Retreat at TimberRidge

ZONE CHANGE

ADJACENT PROPERTY OWNERSHIP

REZONE MAP

ADJACENT PROPERTY OWNERSHIP

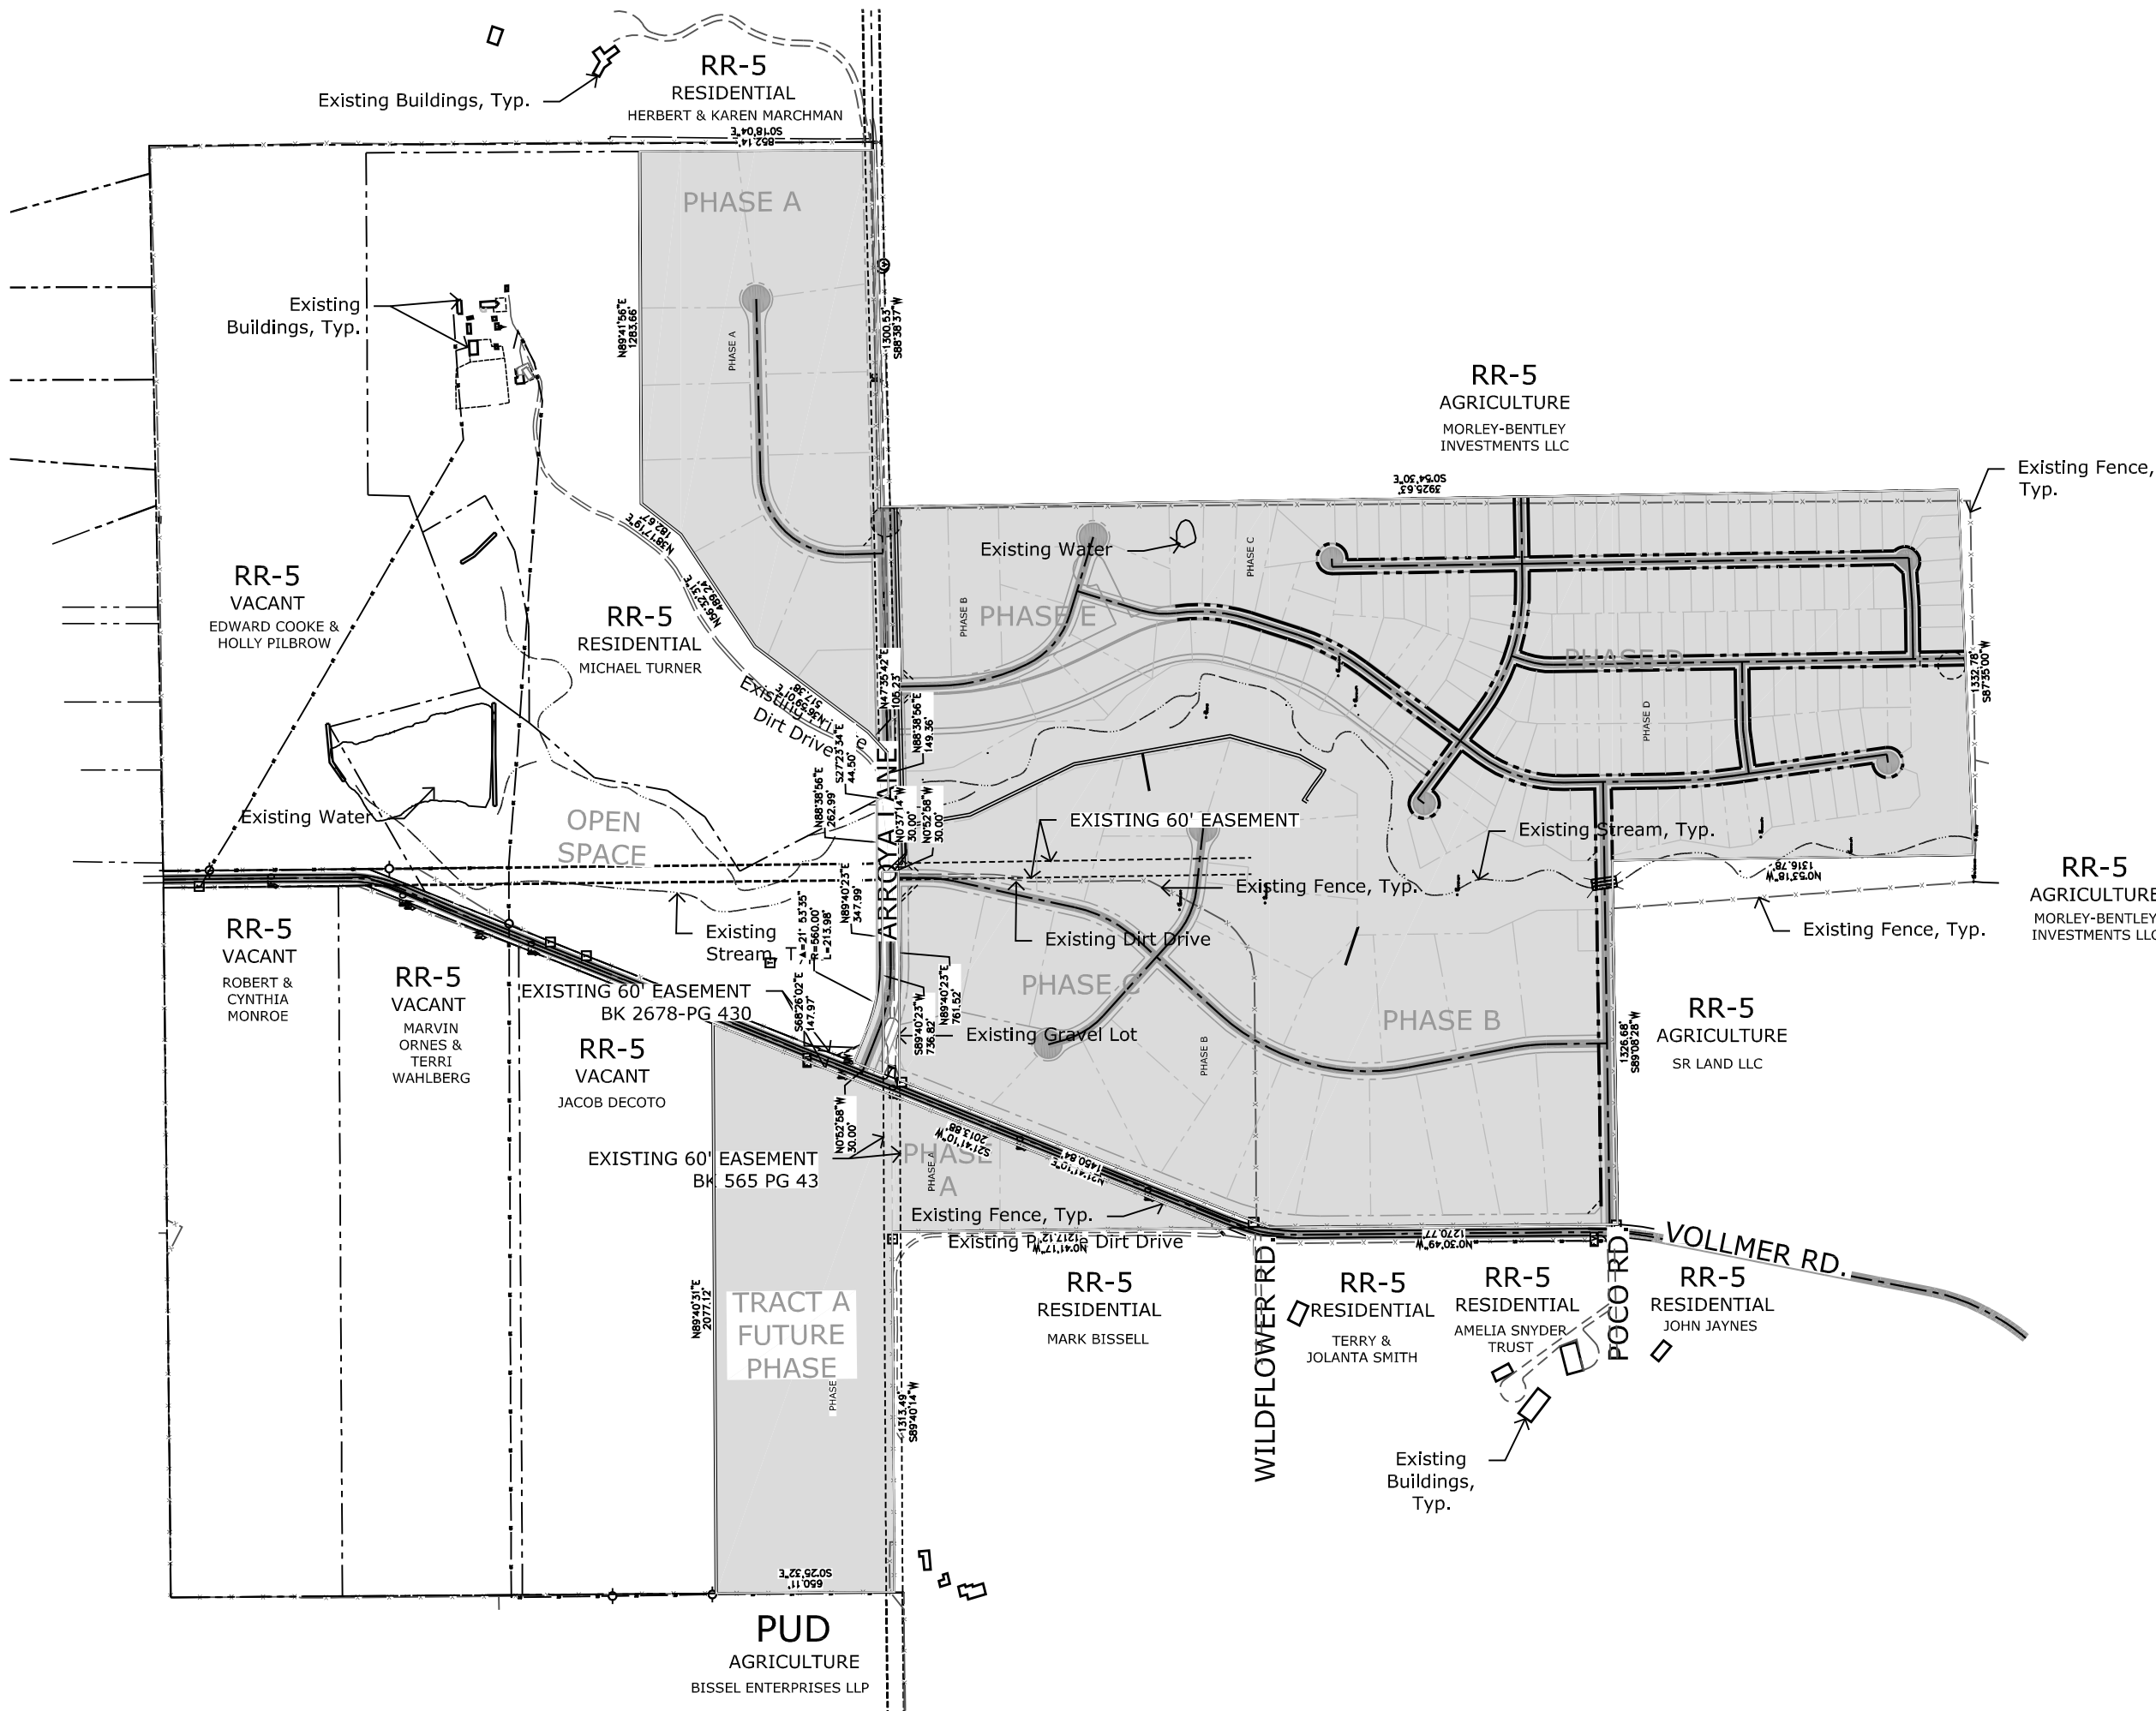
This is not a legal

Owner 2
Address Line 1
Address Line 2

Who? Are you including Jakes other 40?
